# MDT-SF22013-R2-CDs.pdf Markup Summary

DP02 PROFILE
STA 0+00.00 TO 8+74.96

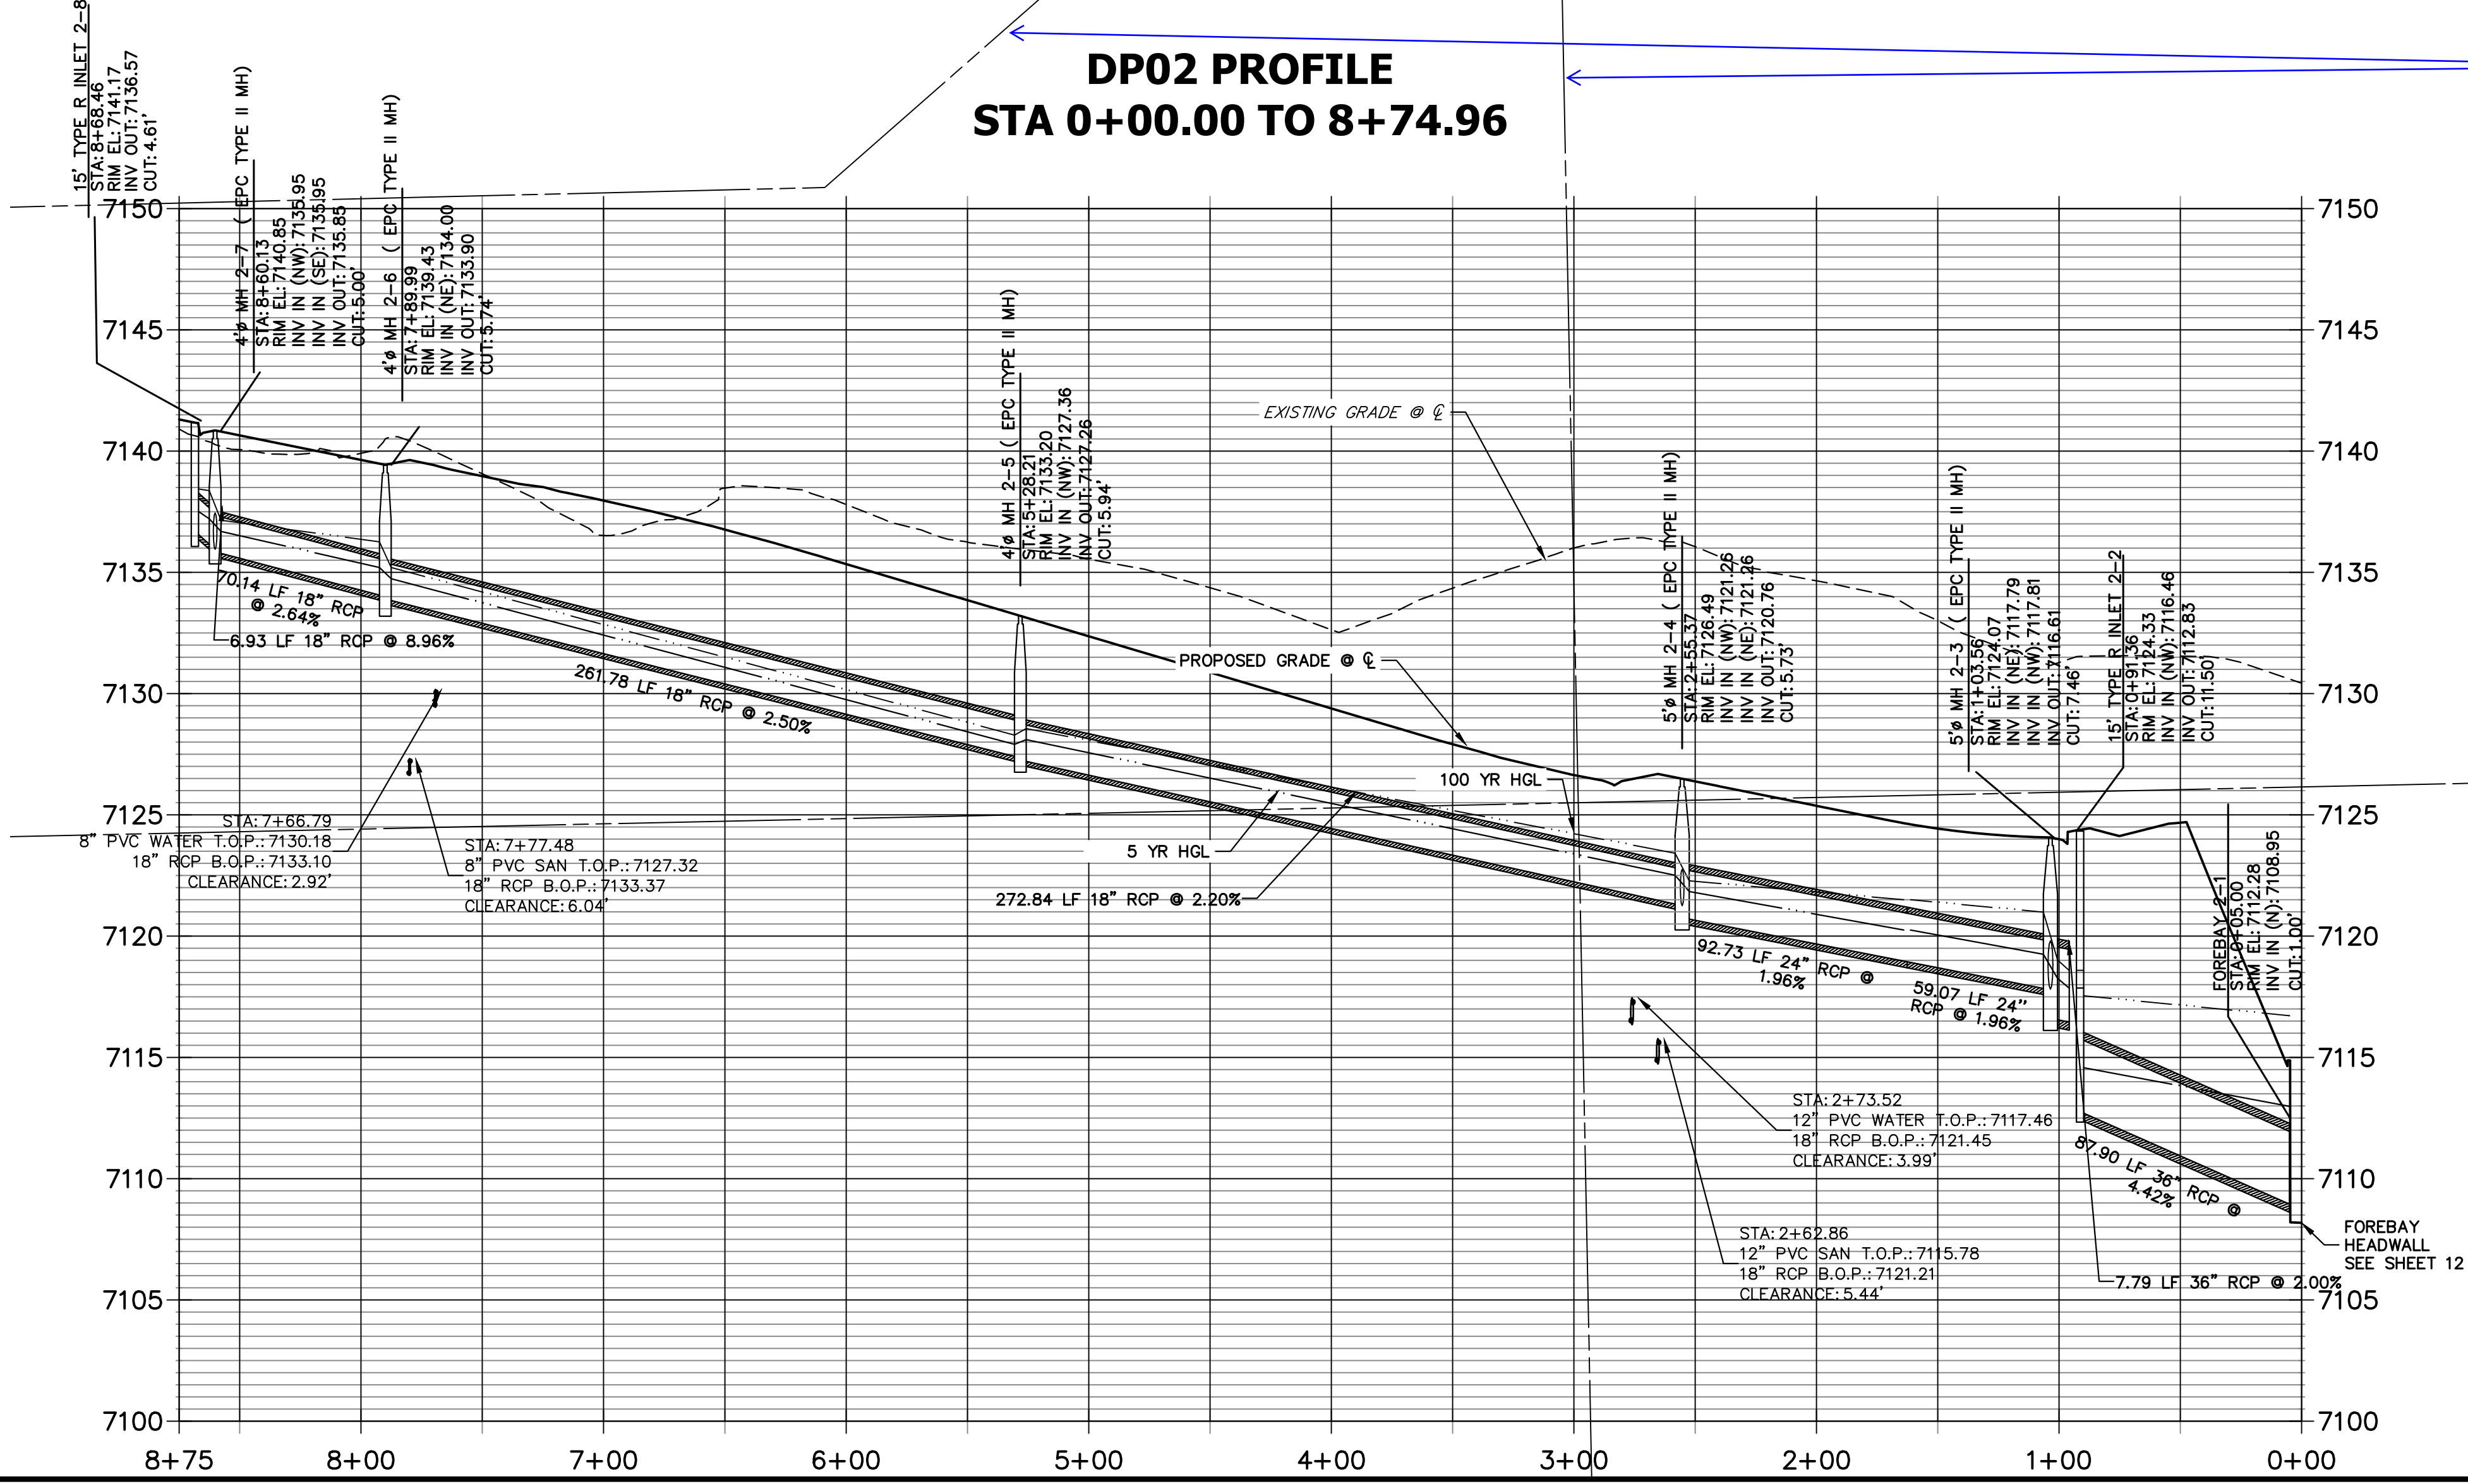
Watertight pipe joints required - add note

Watertight joints required
